CITY OF ALBUQUERQUE PLANNING DEPARTMENT DEVELOPMENT REVIEW BOARD

**5. Project # 1003172** 04DRB-01955 Major-Preliminary Plat Approval 04DRB-01957 Minor-Temp Defer SDWK

TIERRA WEST LLC agent(s) for AMC DEVELOPMENT SERVICES request(s) the above action(s) for all or a portion of Tract(s) 1D, SEVILLE (to be known as **SEVILLE SUBDIVISION, UNIT 9,** zoned R-LT, located on KAYENTA ST NW, between IRVING BLVD NW and CALABACILLAS ARROYO containing approximately 8 acre(s). [REF: 04DRB00529] (A-10)

PRELIMINARY PLAT

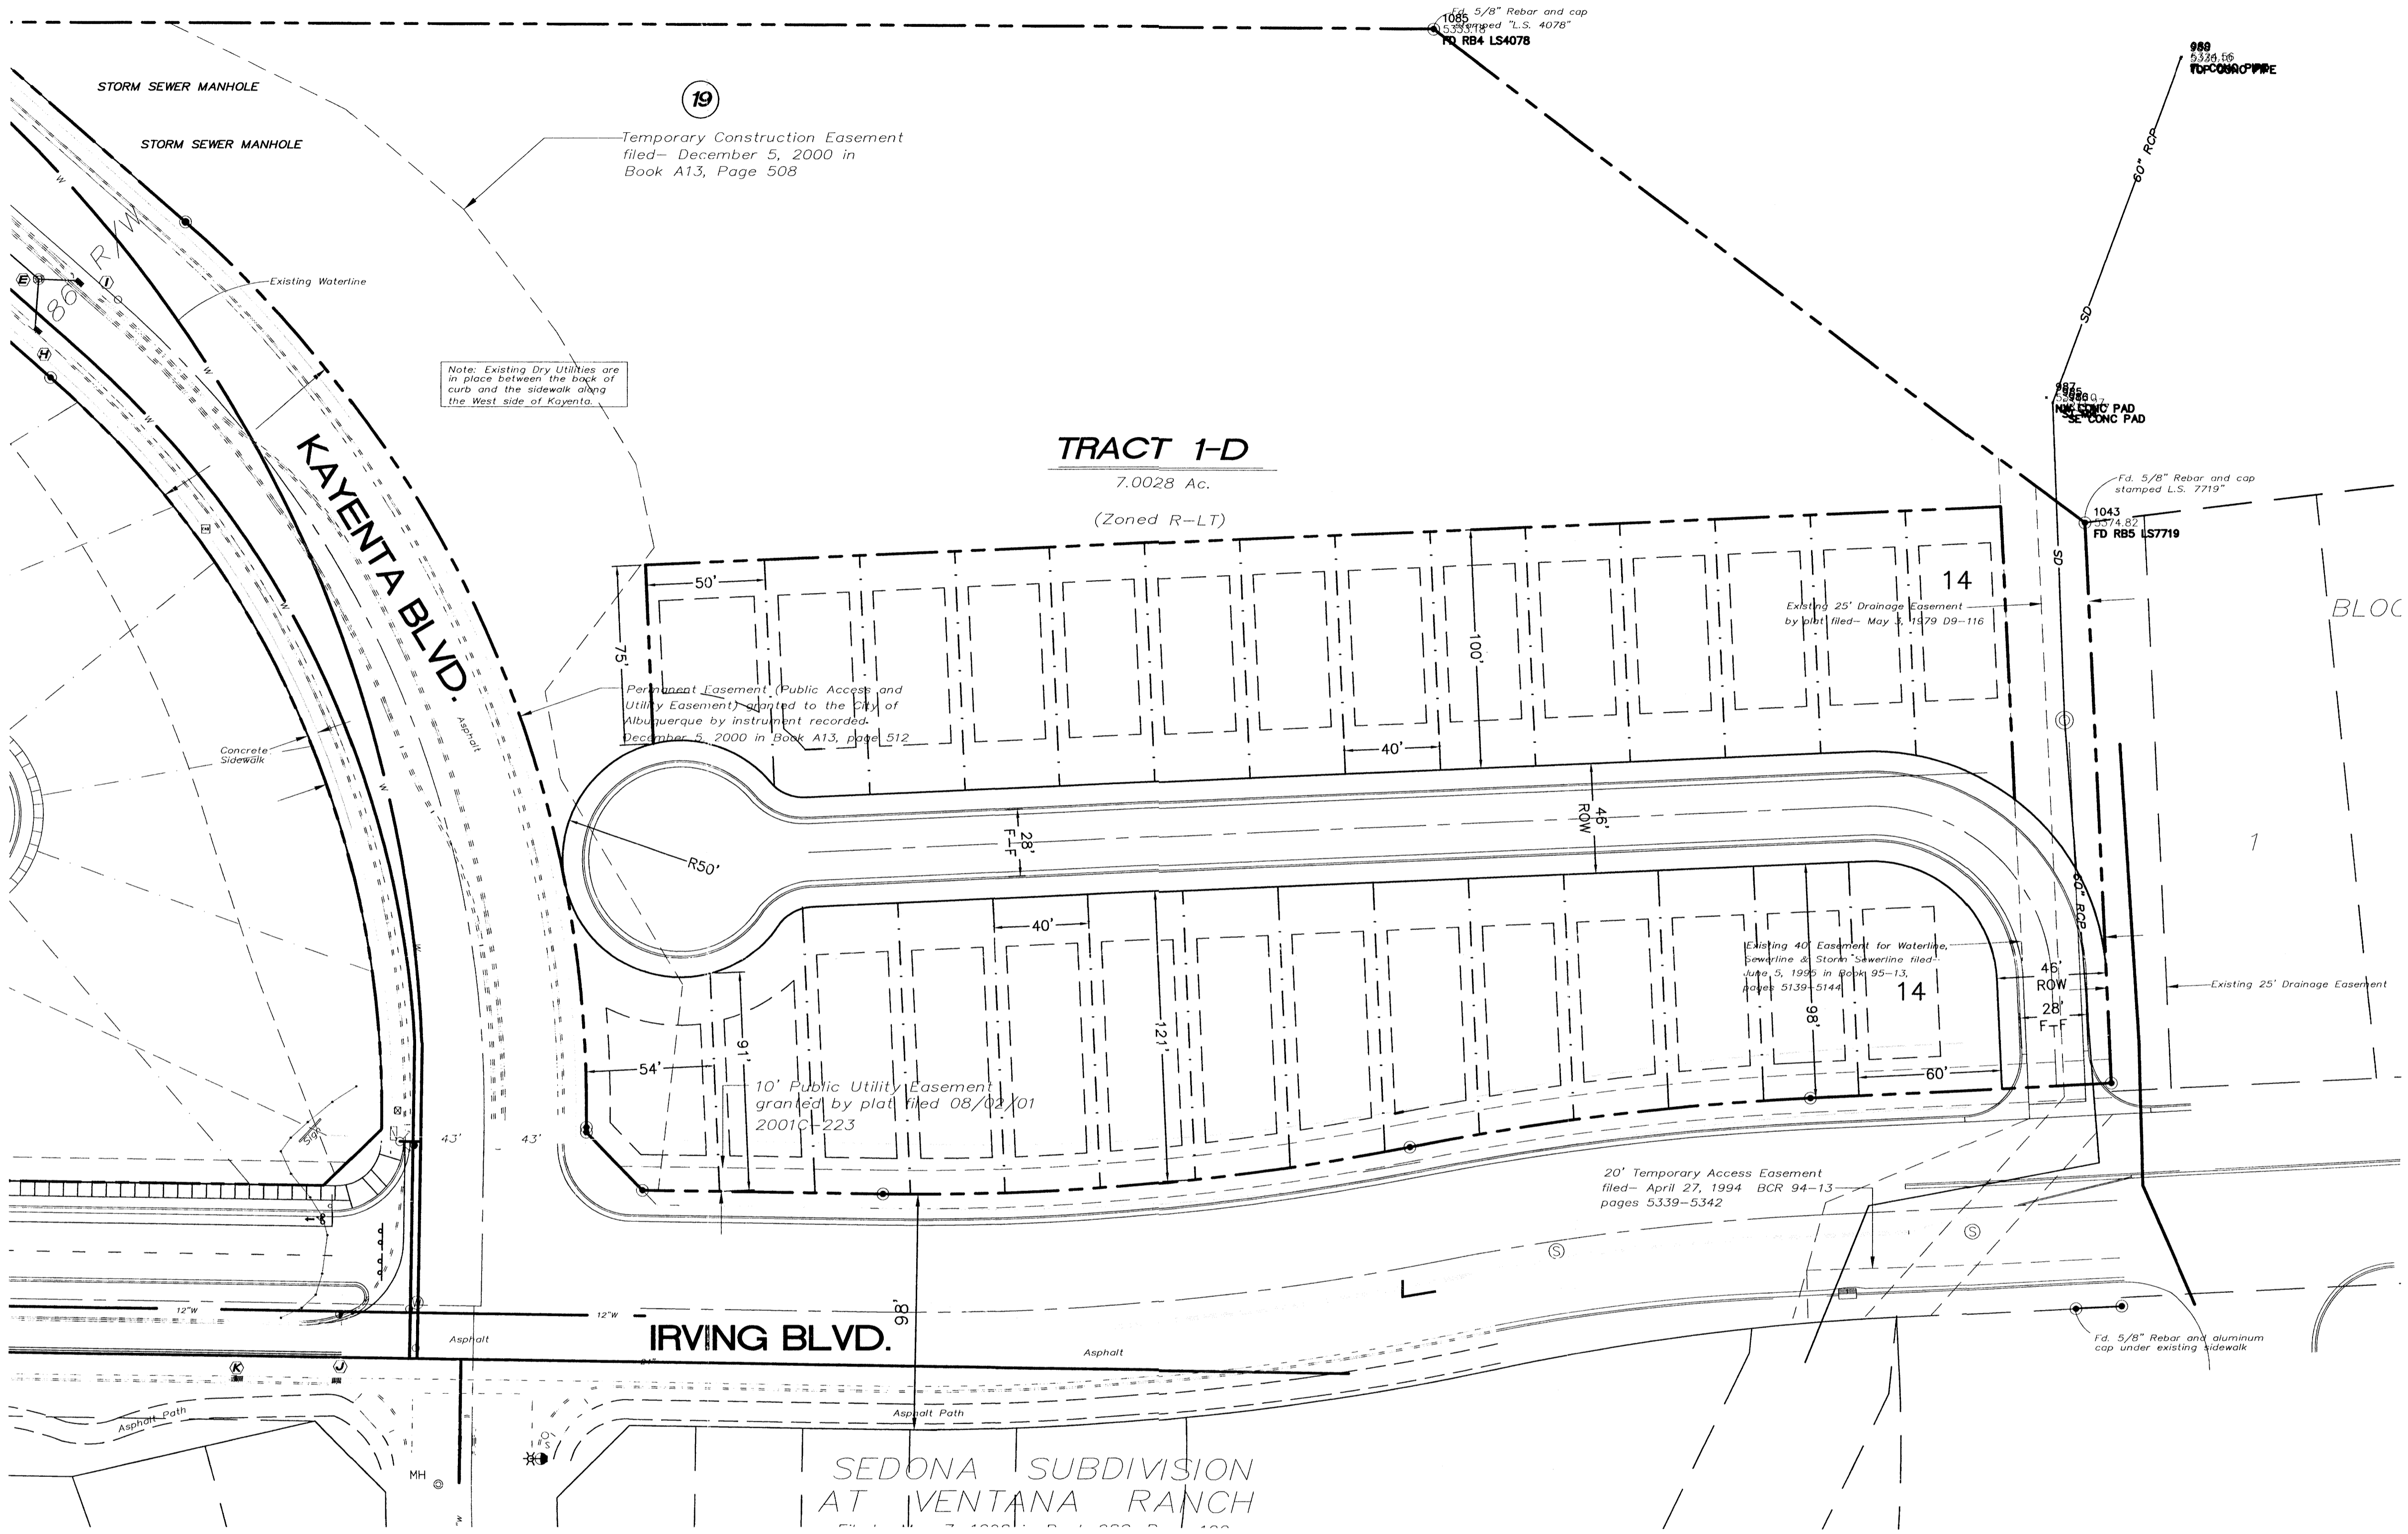
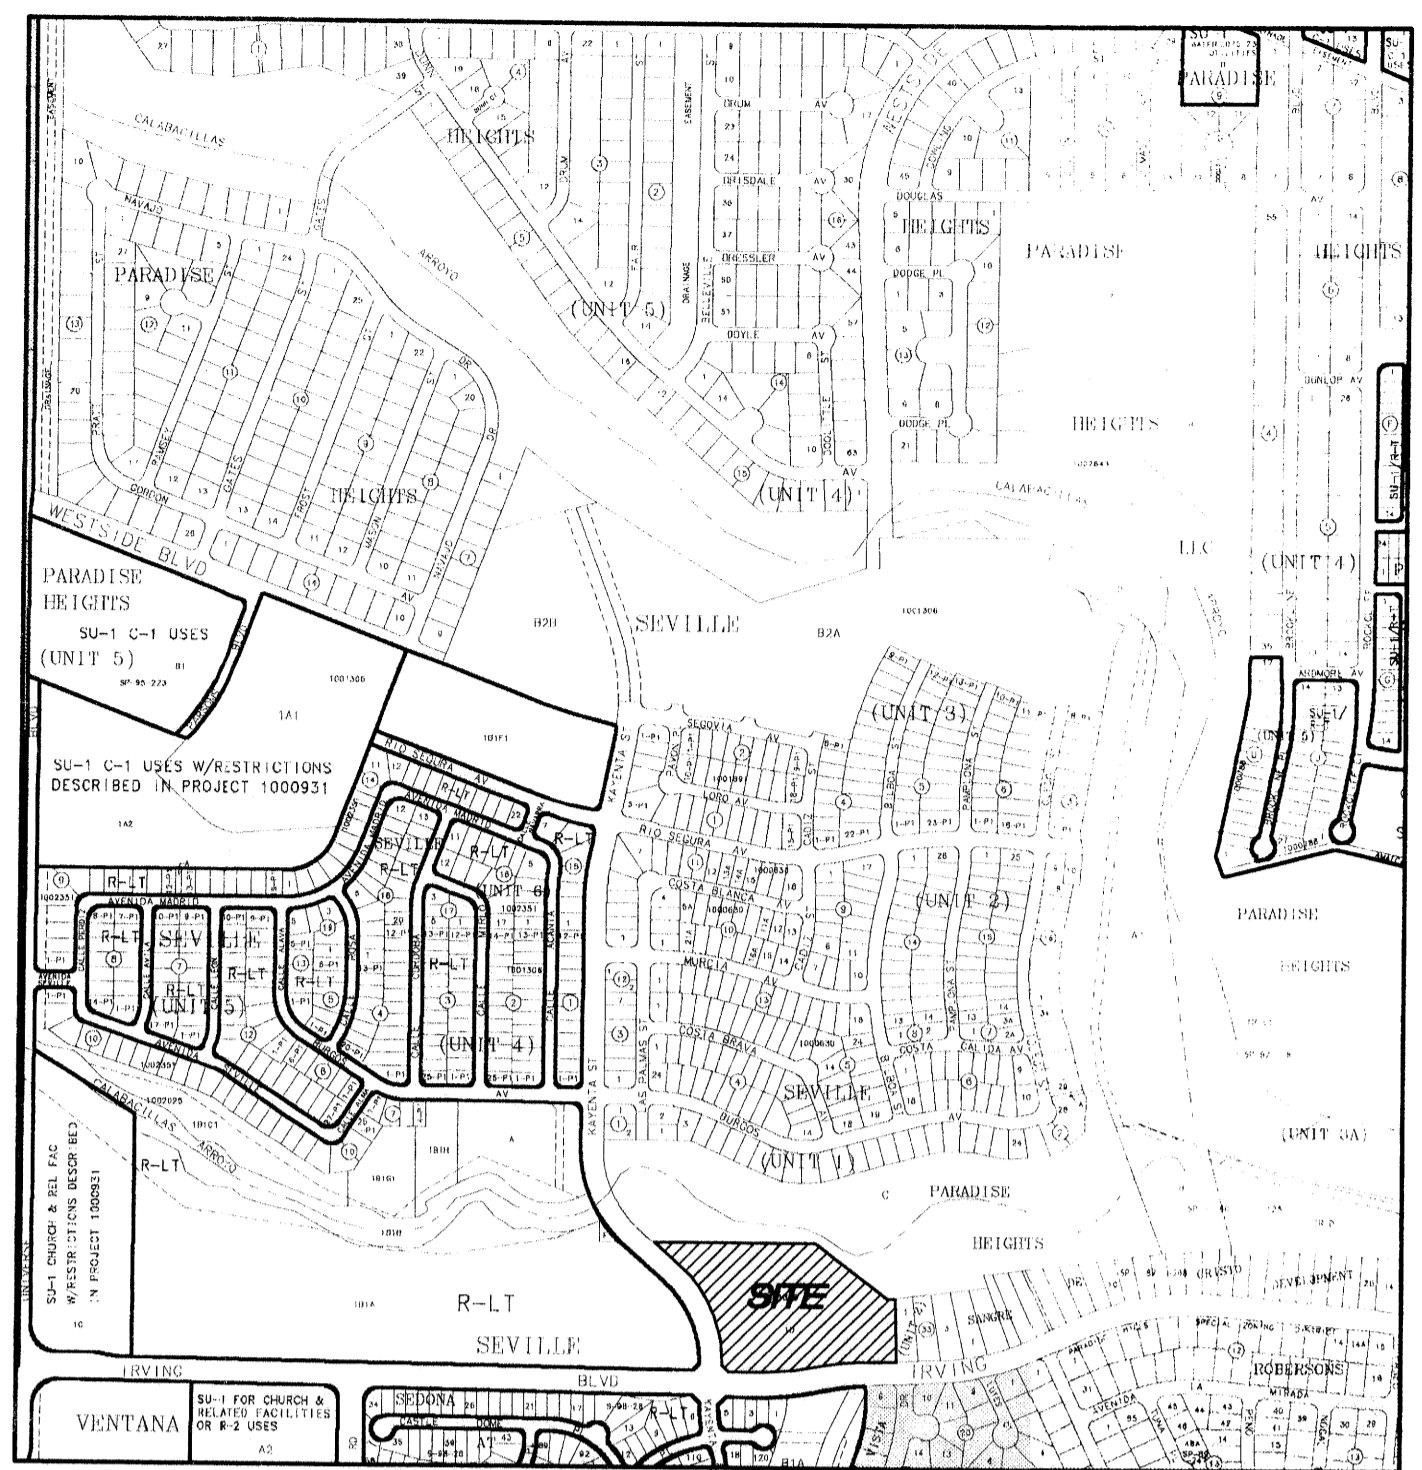
To reevaluate the location of intersection of Pyrenees Court and Irving Blvd.

To show the 20-foot pedestrian easement on the final plat.

To grant the 20-foot public sanitary sewer easement to the City of Albuquerque as well as New Mexico Utilities Inc.
